Application for Approval of Details Reserved by Condition

GTR NEW SITE

5,000 sq mts of light Industrial floor space(B1(b)/(c) and associated works including access, and internal road network, highway works, landscaping selected tree removal, informal and formal open space and play areas, pedestrian and cyclist infrastructure, utilities, drainage infrastructure, car and cycle parking and waste storage in accordance with application ref WA/22/15/OUT

12 and 20

Catchpit Detail 1200mm Ø

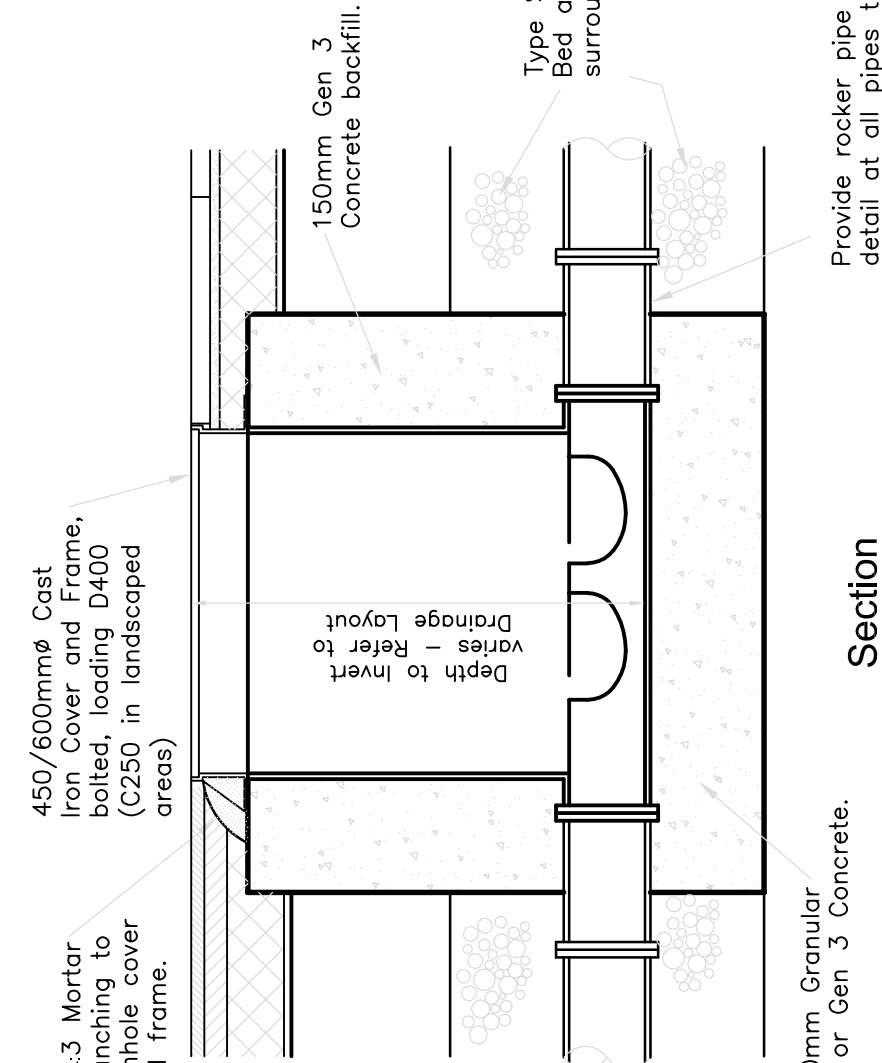
- 2.Catchpits still have not been provided upstream of connections into permeable paving sub-base. Stating that there will be filter socks is insufficient. We acknowledge that the filter socks will prevent silt ingress into the sub-base, however over time the permeability of the filter material will decrease as silt builds up on it, with no easy means of maintenance.

Athlon SFA10D Headwall Installation

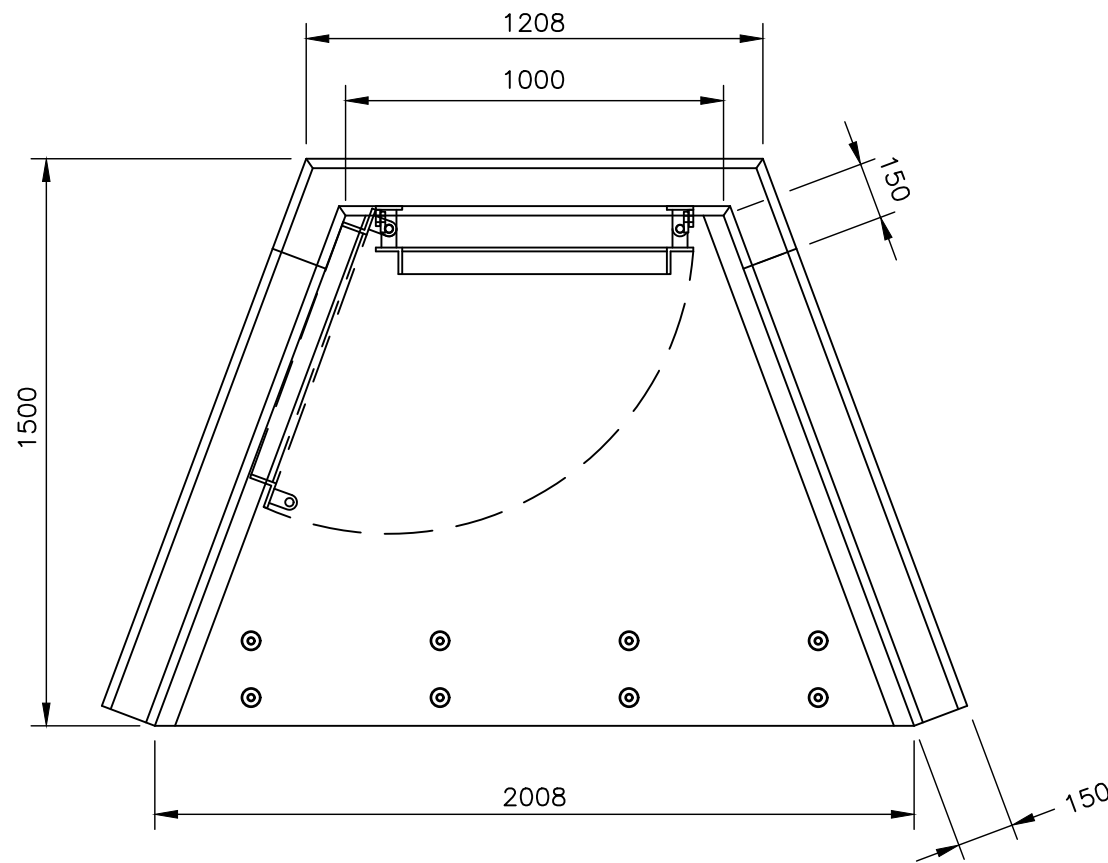
- 4.Construction detail drawings should be site specific. So there should not be a hydrobrake included on details. Construction details of the infiltration basin should be provided including the headwalls into this.

Drg No.	Rev.
15104/21	D

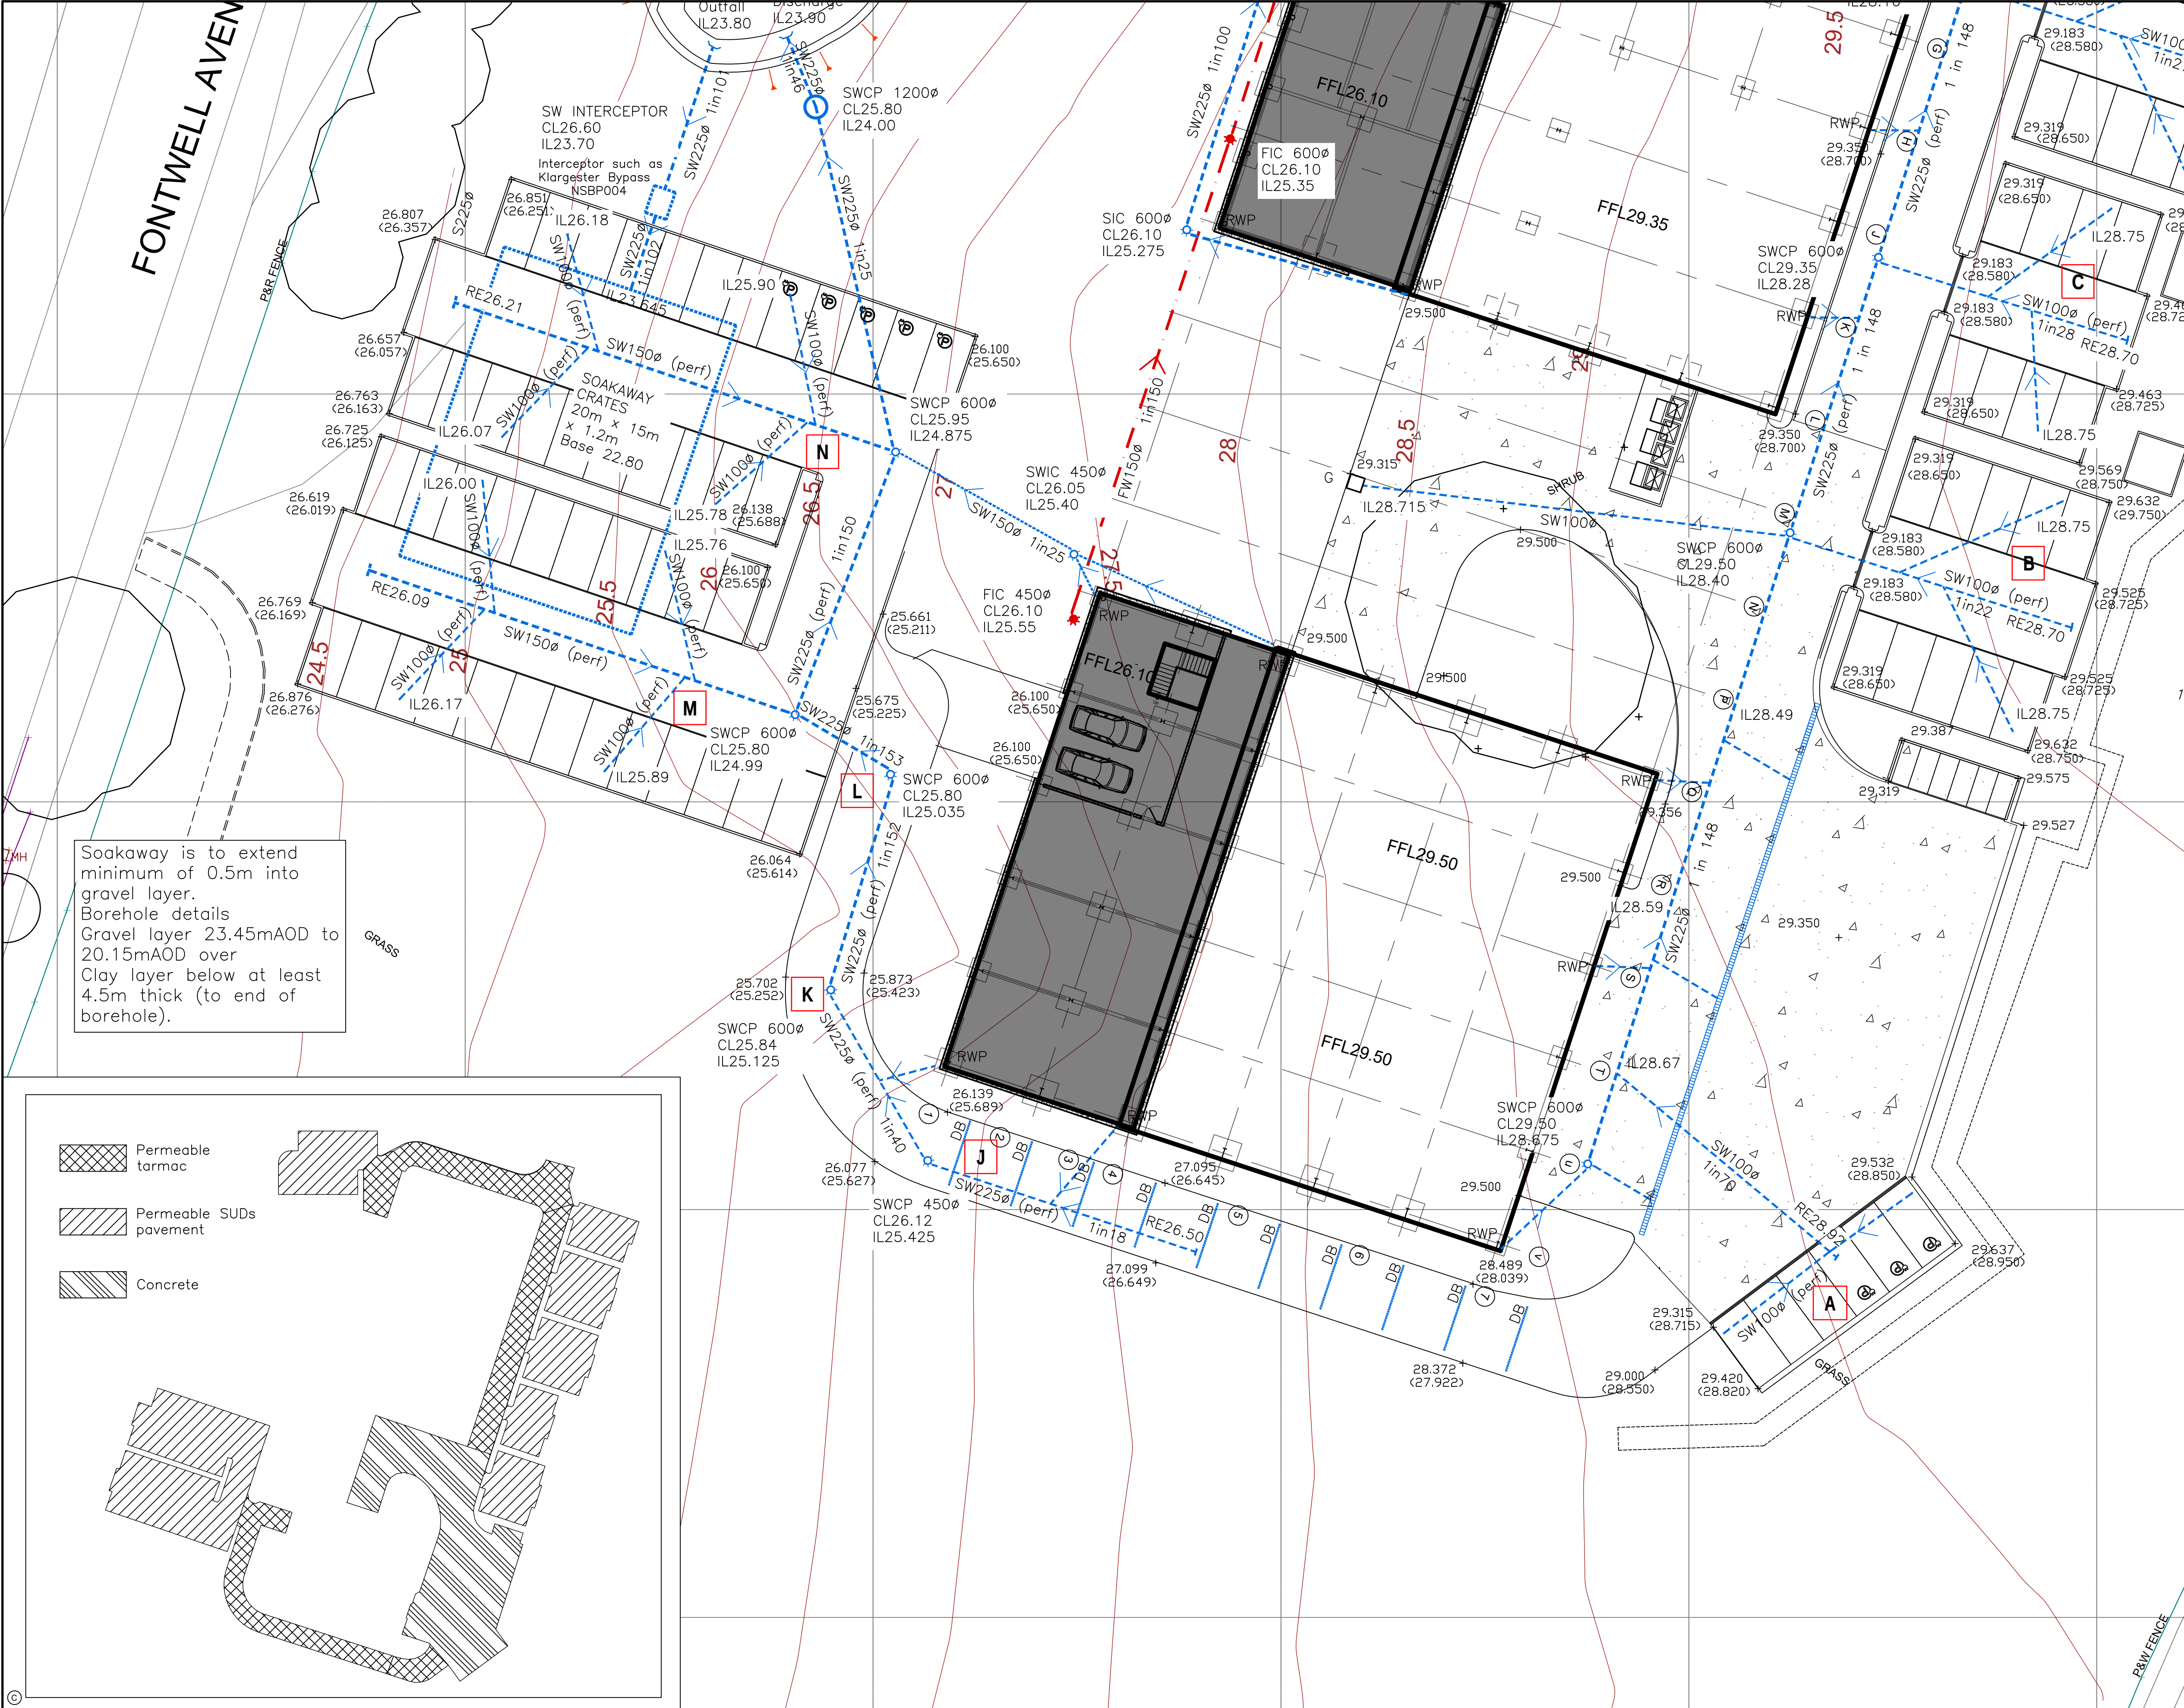
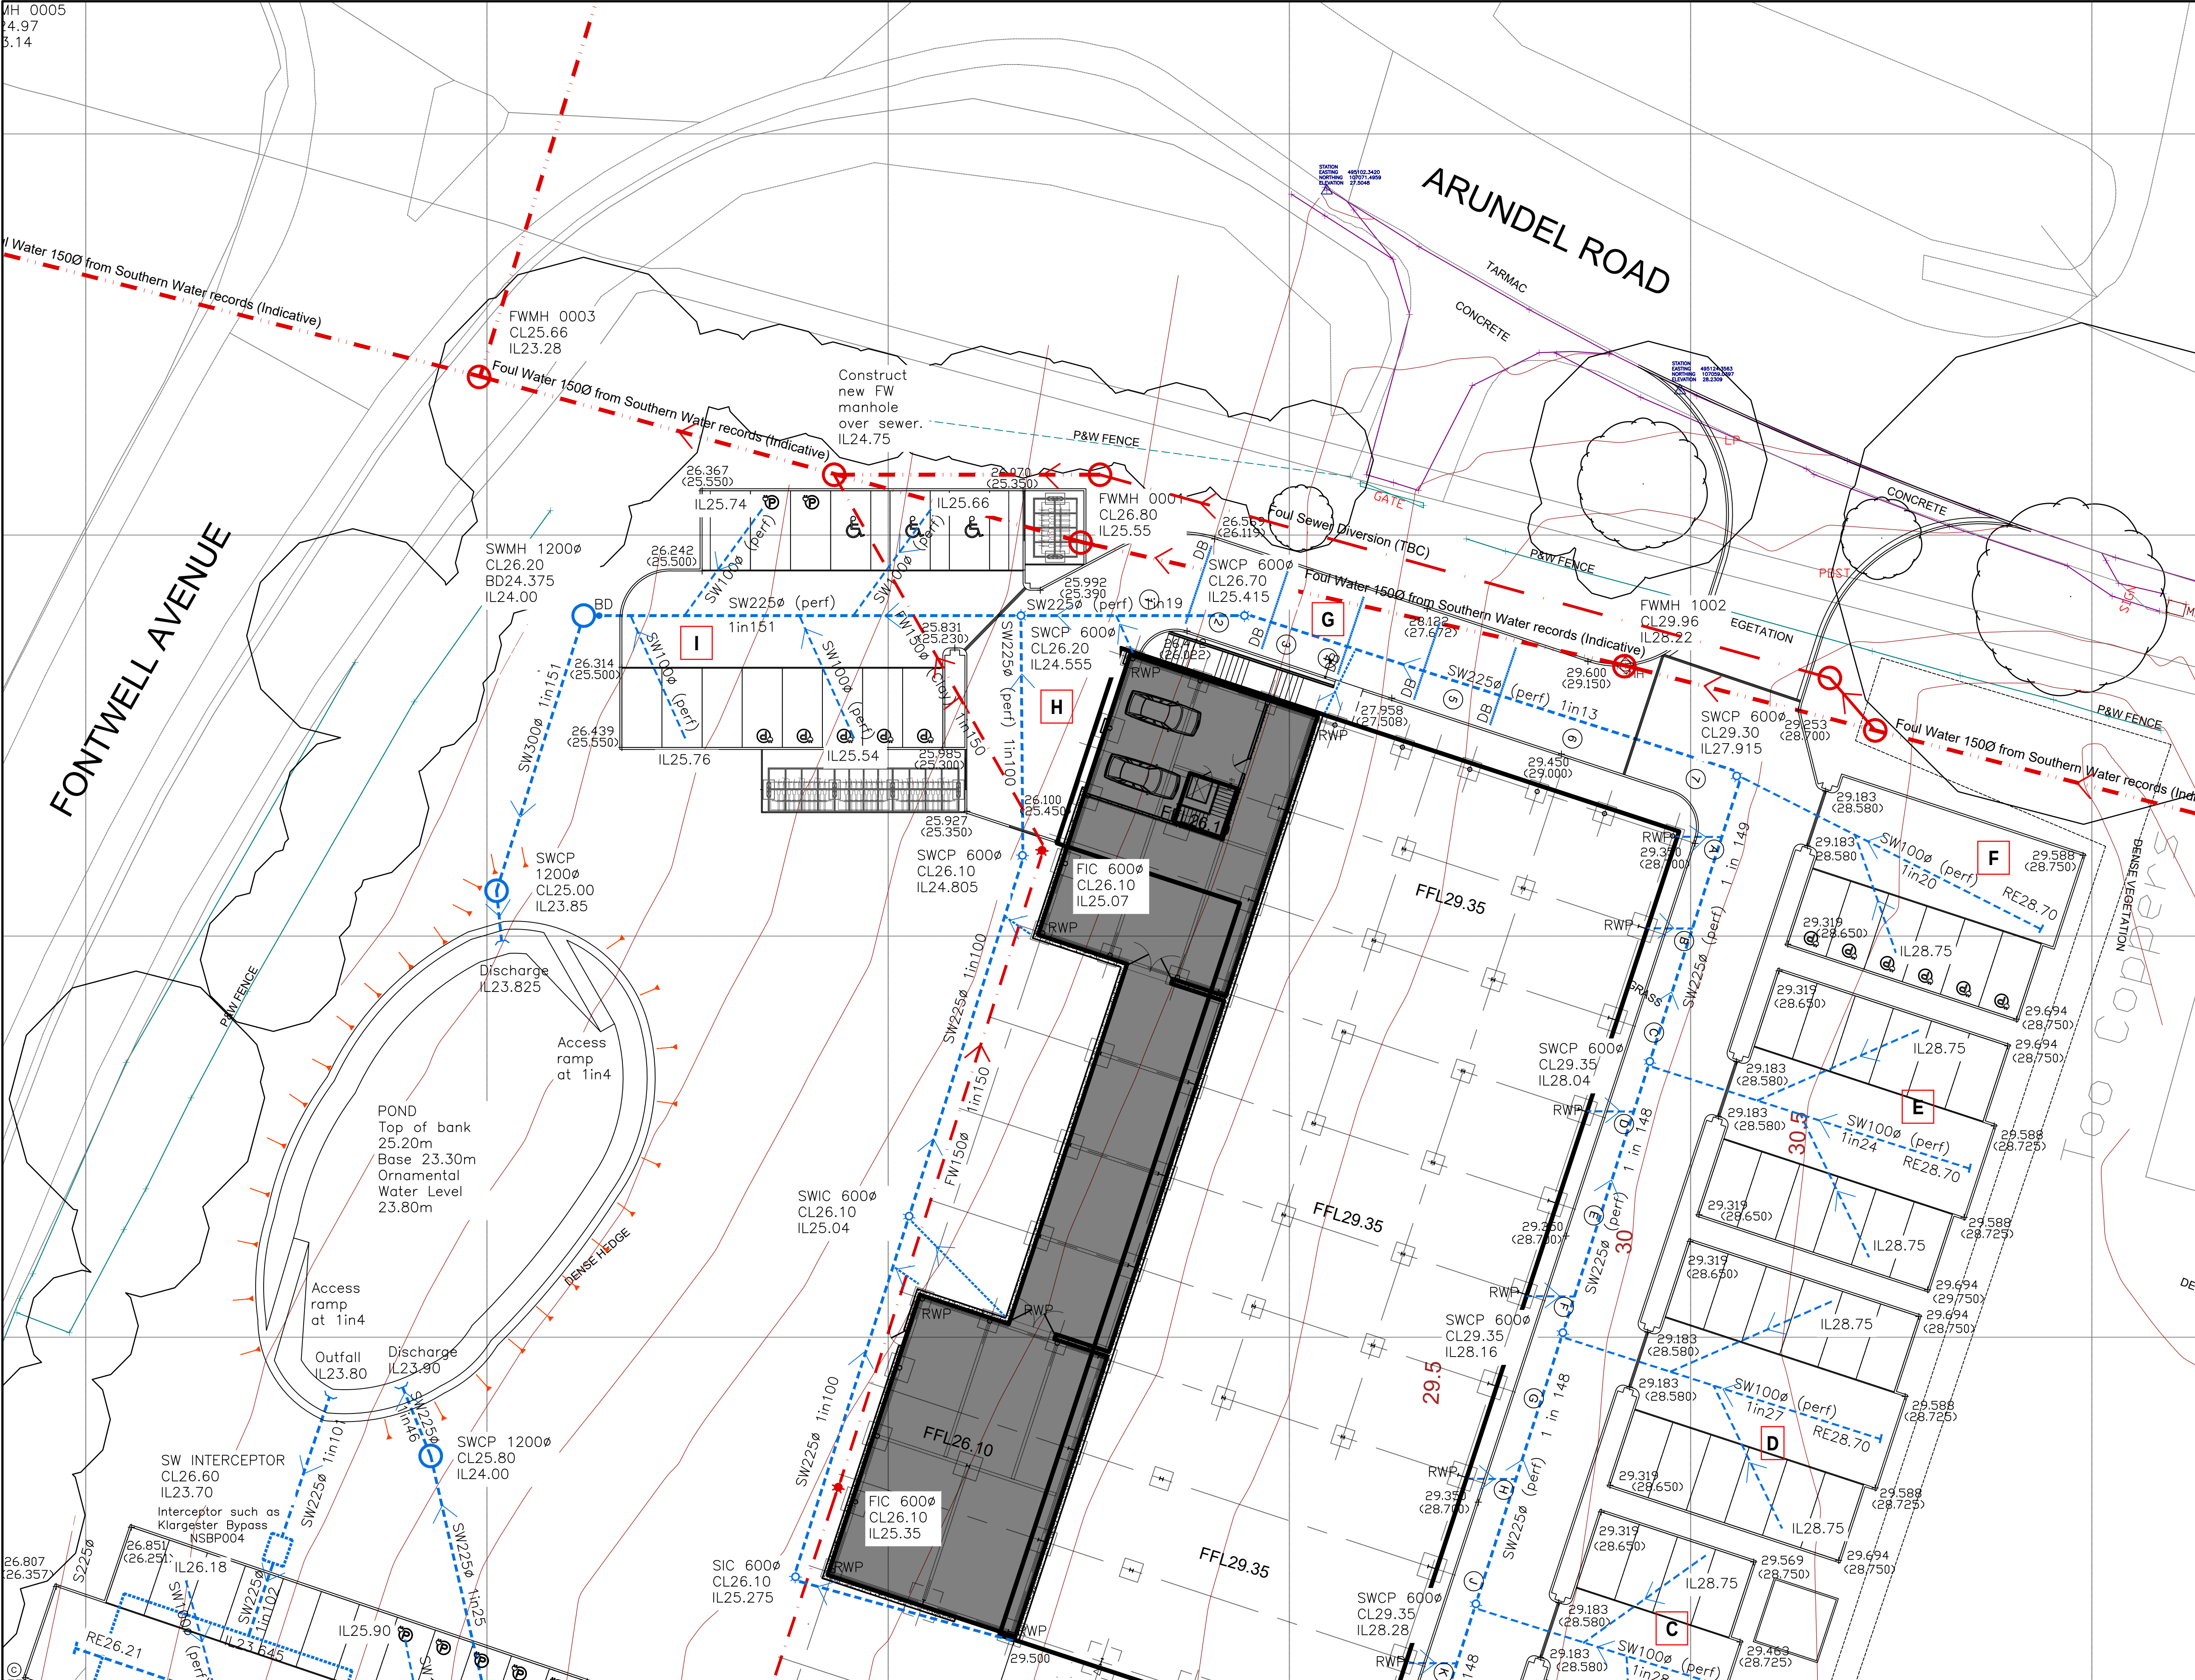
- 1.Permeable paving extents are not very clearly shown, a small insert layout is provided on one layout only. Permeable paving extents should be clearly shown on all layouts.
